RE: **Country Club Plaza** - 1720 Central Avenue SW
Grading and Drainage Plan for Site Plan, Building Permit and Work Order
File: **J13-D010**
PE Stamp: **3-18-2014**

Based upon the information provided in your submittal received 3/18/14, the subject Grading and Drainage Plan meets the criteria for Site Plan, Building Permit & Work Order approval.

RE: **Country Club Plaza** - 1720 Central Avenue SW
Grading and Drainage Plan for Building Permit

Based upon the information provided in your submittal received 2/14/14, and the revised plan received 3/4/14, the subject Grading and Drainage Plan cannot be approved for Building Permit.

Country Club Plaza  
SWC of Central Avenue and Laguna Boulevard  
Albuquerque, New Mexico 87102  
GRADING & DRAINAGE PLAN

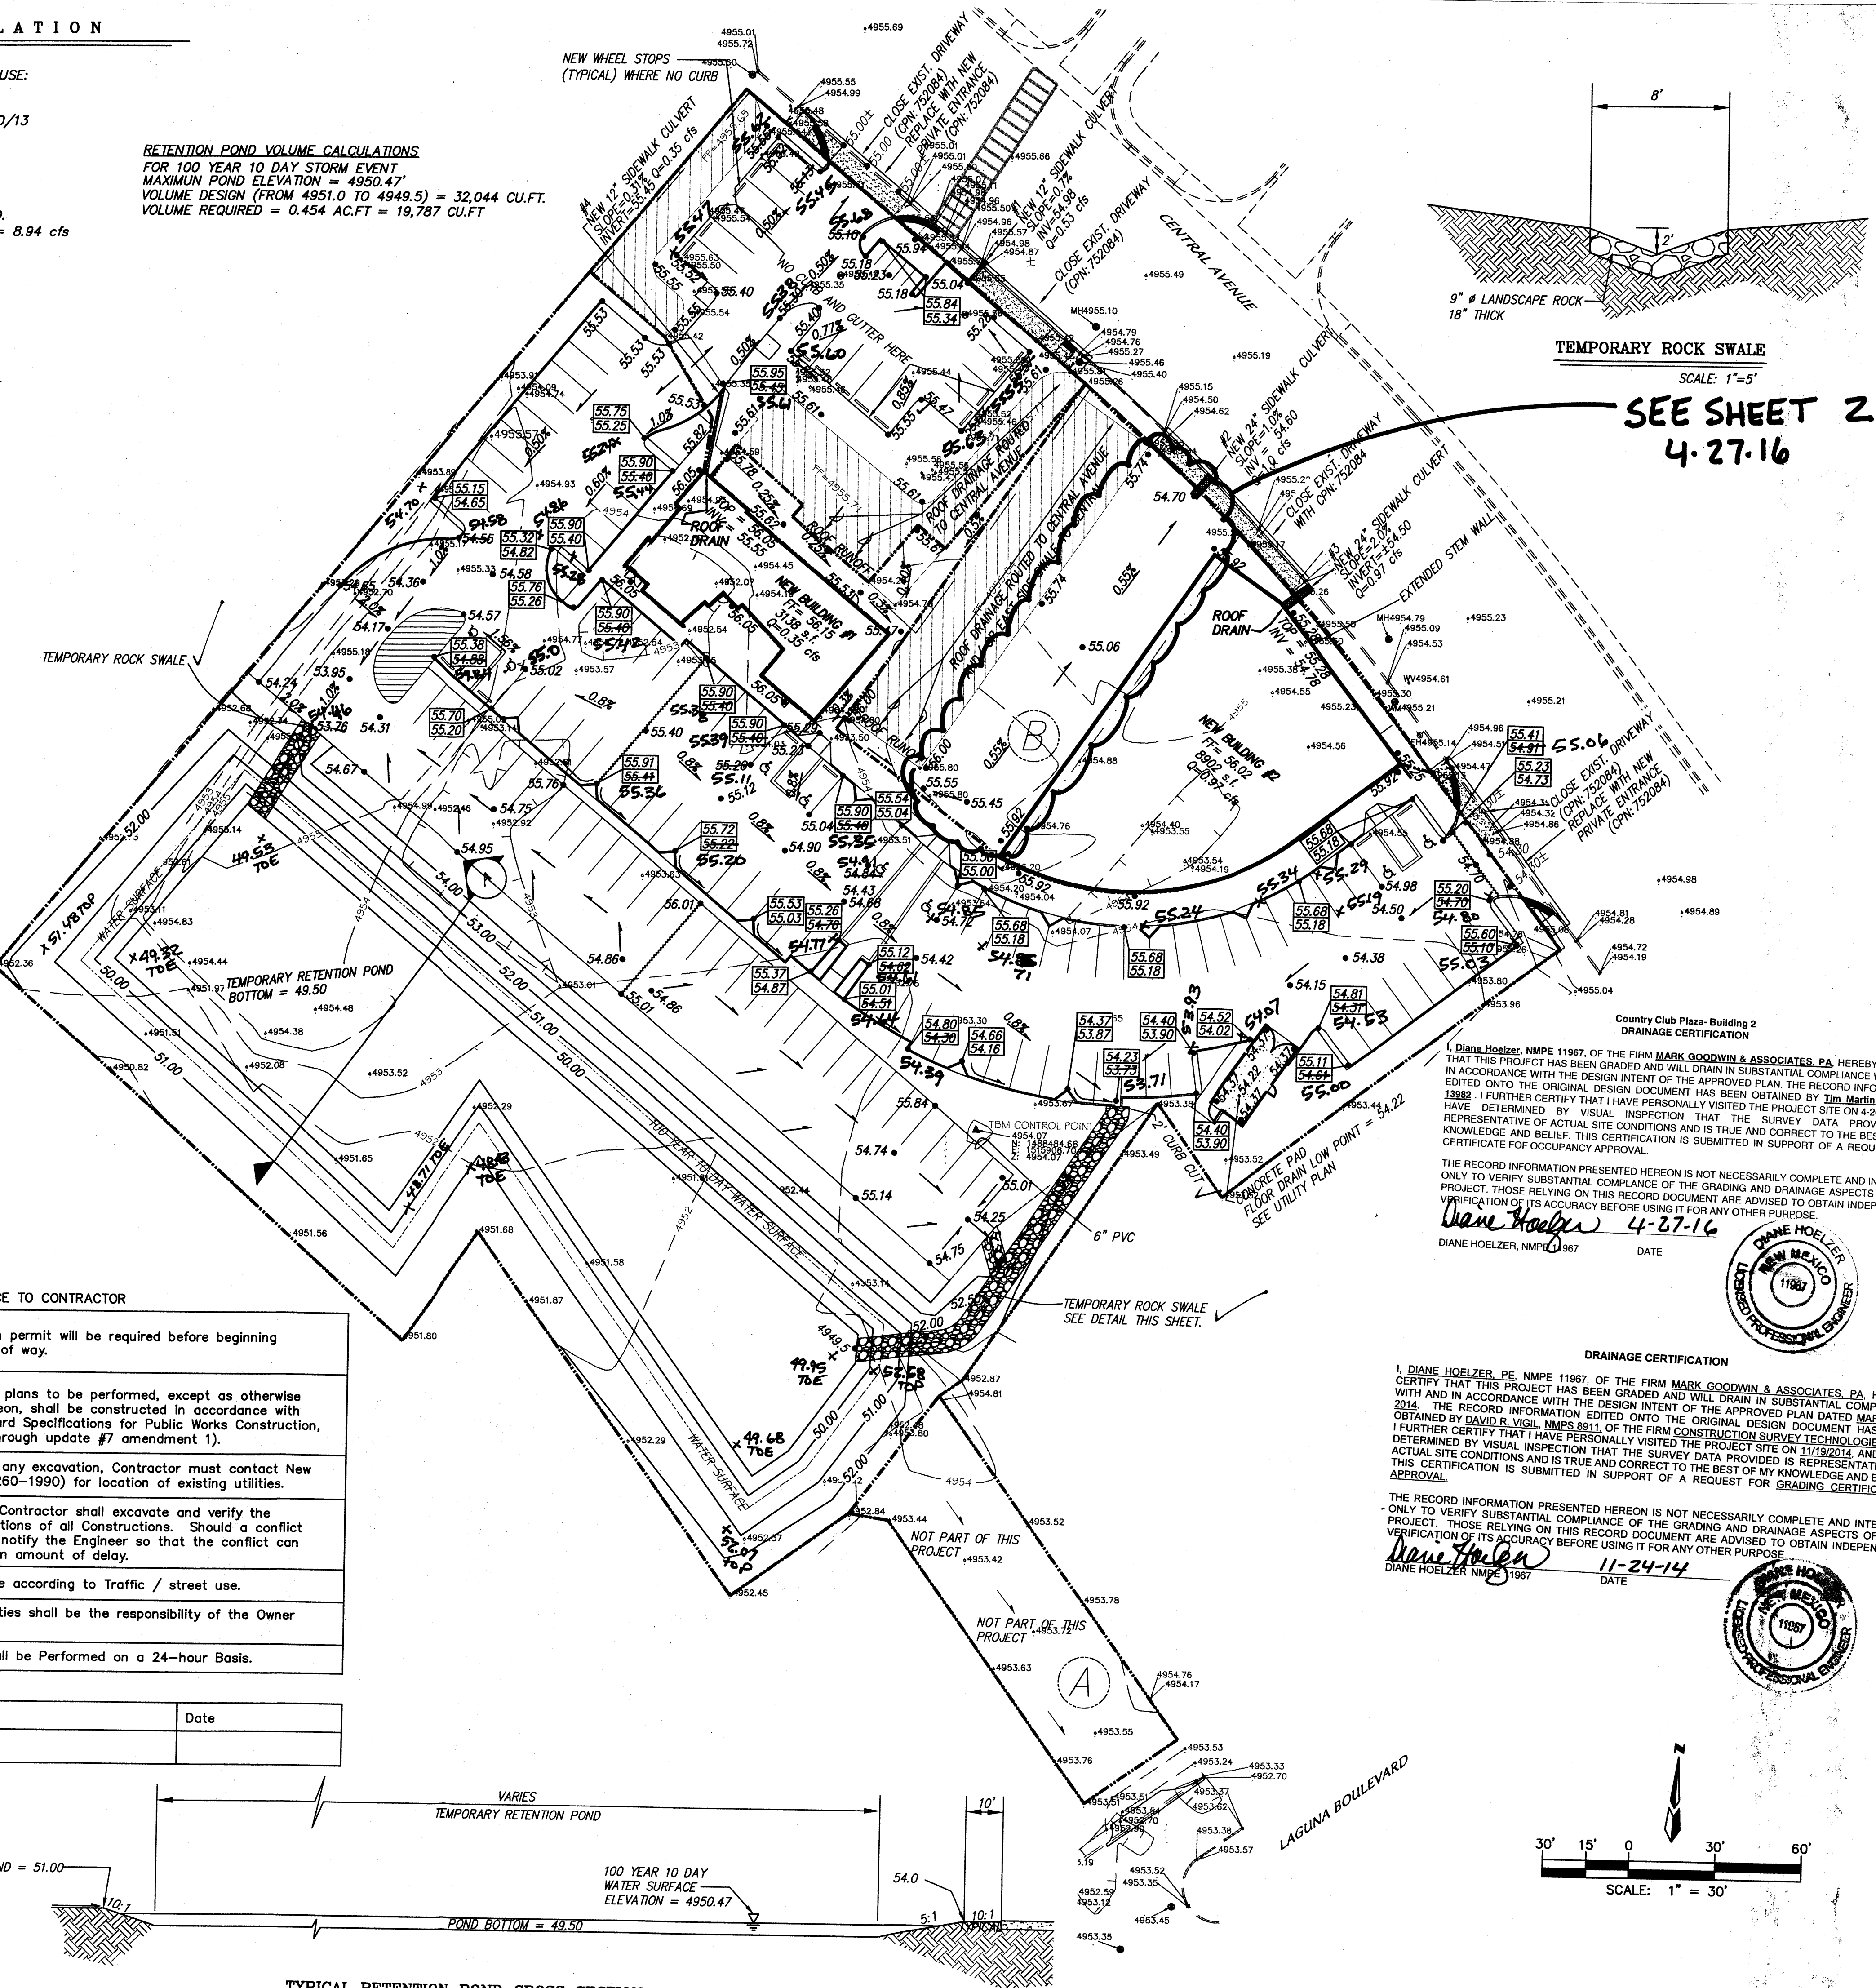
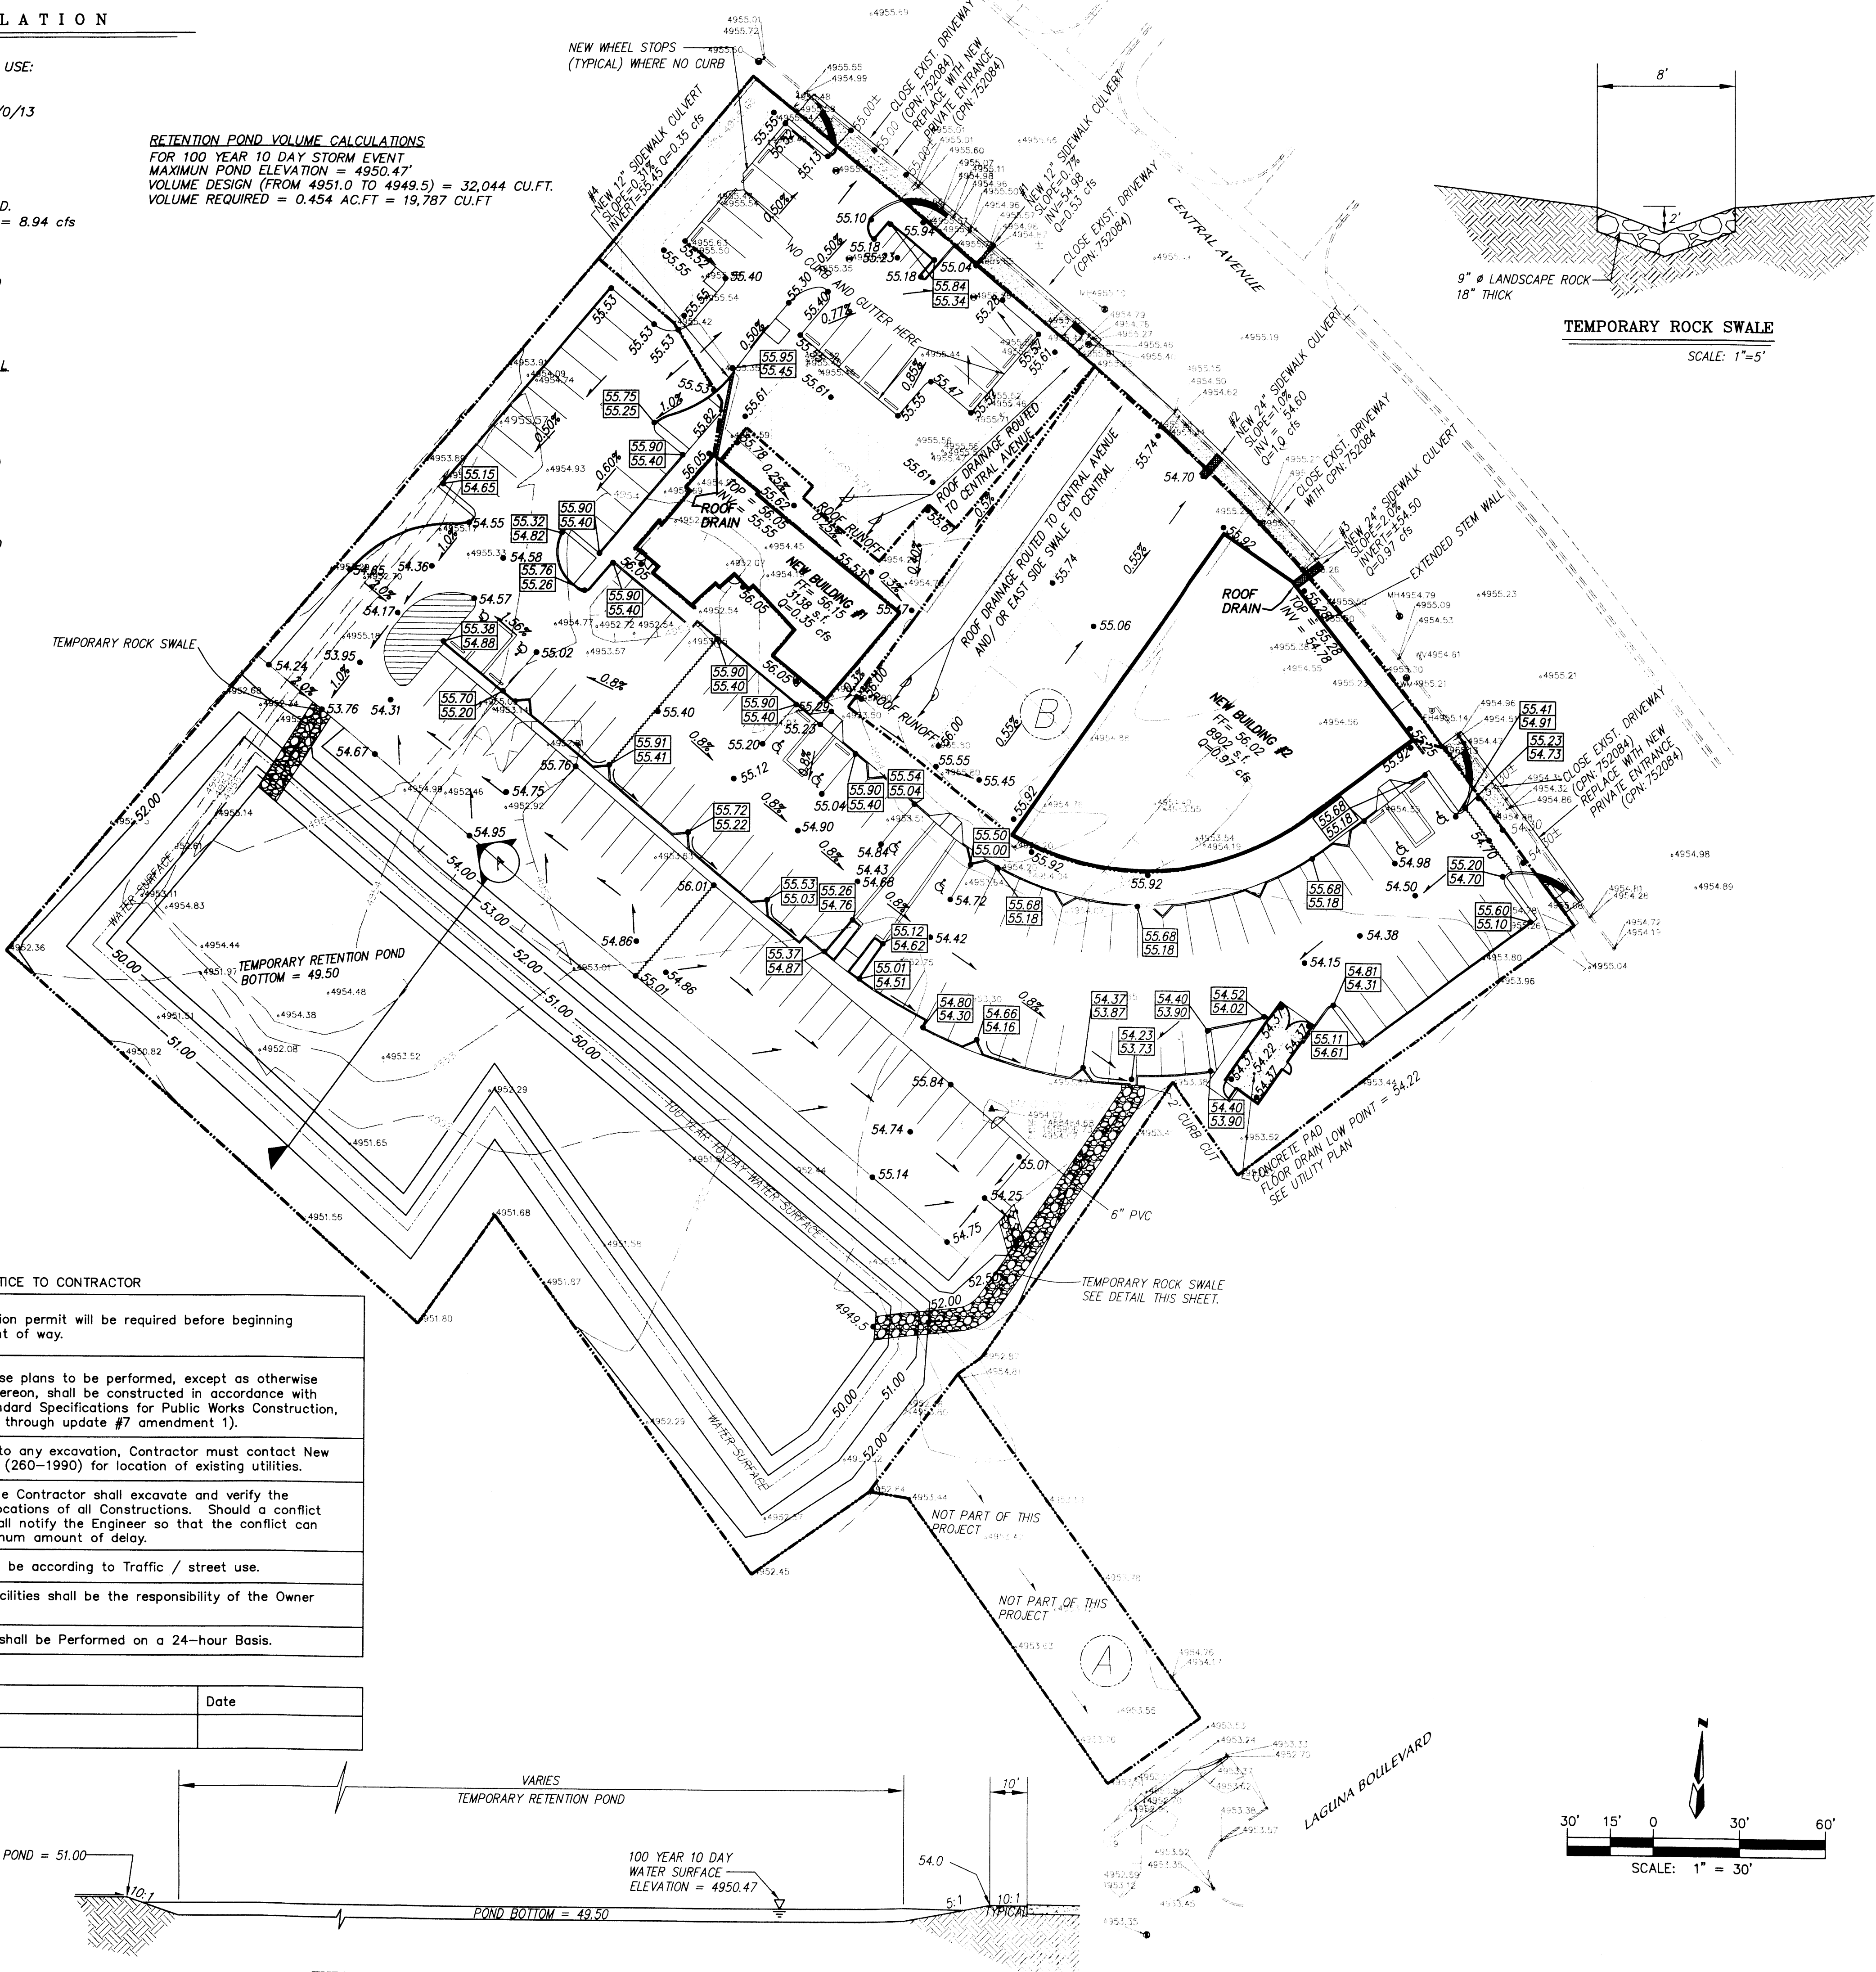
1. Show where the existing building roof drains enter the basins?
2. Show how the courtyard between the existing service station building and Future Bldg #2 drain to Central. Spot elevations appear to be below top of curb grades.

3. Show on this plan the driveways to remain open and which are to be closed by Work Order (cpn-752084?). Driveways may be outfall points for drainage.

4. The area between the existing buildings appears to drain to the dashed line that runs to the south pond. If so that's in Basin B and draining to Basin A, rather than B to Central. Does the pond volume accommodate that runoff?

5. Clearly label the dashed line (6" PVC Drain to pond) with grades and bend locations.
6. The sidewalk culverts proposed for the Bldg #1 roof runoff appear to discharge at the high point on the drive lane, and could potentially drain back south to Basin A. Provide more detail to ensure flows go to Central.

7. There is an existing CMU wall crossing the portion of the site that leads to Laguna? Show how runoff will get through it to the pond.
8. On the calculations table, include a value for the site acreage used to establish the allowable Q.

9. Label the Retention Pond with WSE, Volume Required, and Volume Provided. Confirmation of these features will be required as part of the Certification for CO.
